RE: GRADING & DRAINAGE PLAN FOR PHASE 2, TRACT K, CANYON ACRE

RECEIVED MAY 7, 1996 FOR BUILDING PERMIT

**ENGINEER'S STAMP DATED 05-02-96** (L-22/D2)

DESIGNED BY	DATE	BY	REVISIONS	JOB NO.
GRB				960411
DRAWN BY	DATE	BY	REVISIONS	DATE
E.M.S.				04-1996
APPROVED BY	DATE	BY	REVISIONS	SHEET
J.G.M.				2 OF 2

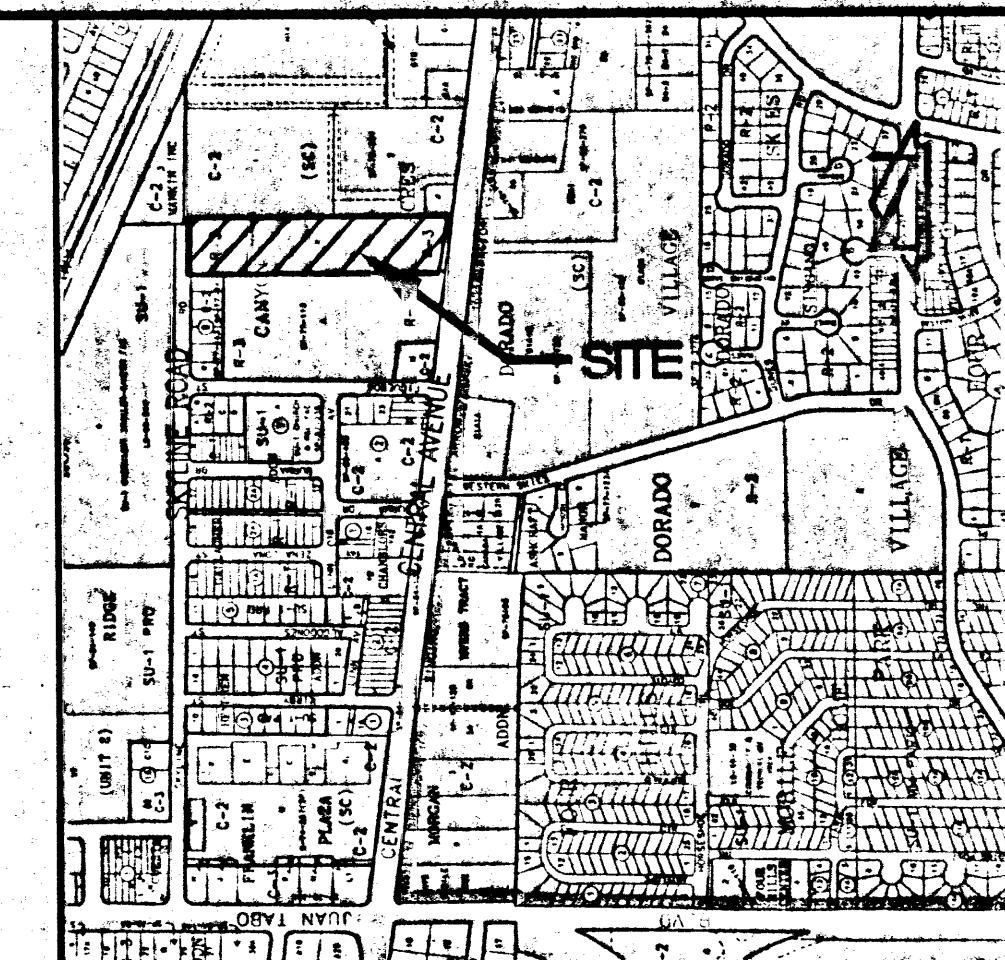
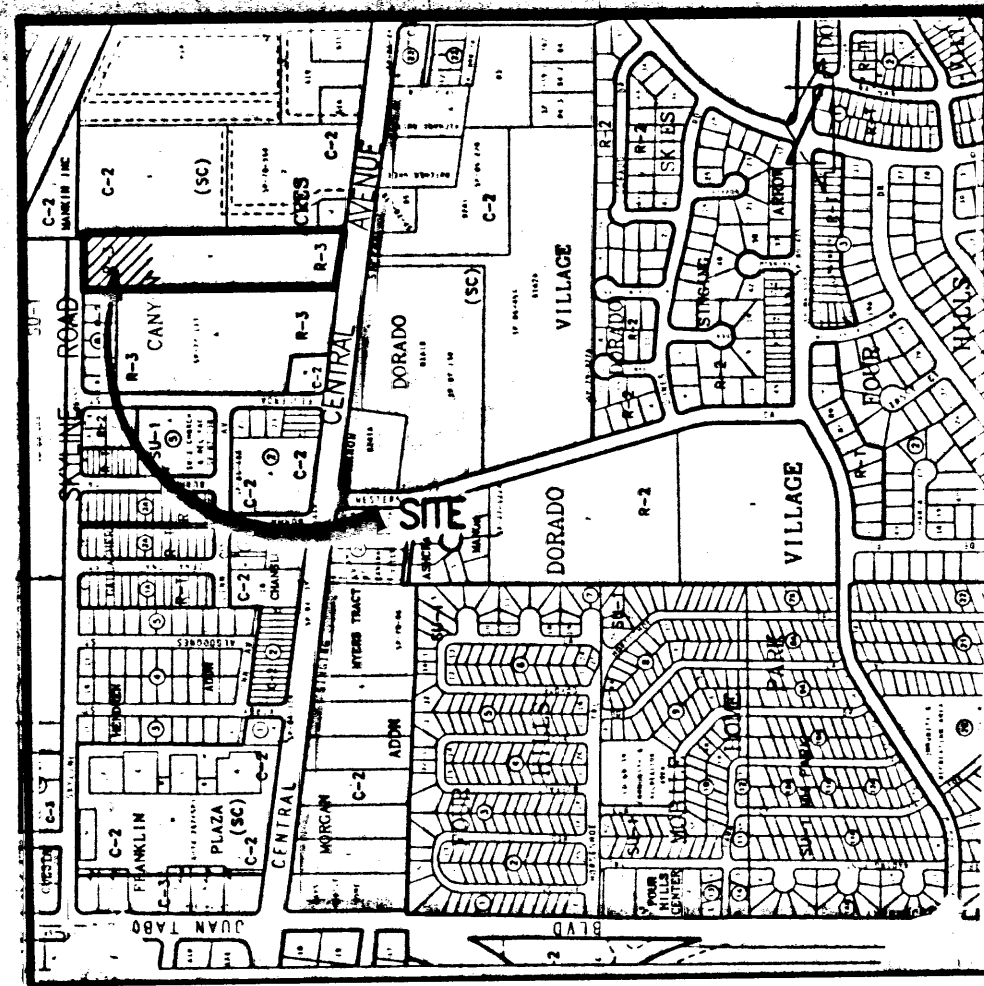
The FF elevations of the southern buildings are 2' lower than indicated on the Master Plan dated 03-16-95. Will this have a negative impact on the development of Phases 3 & 4?
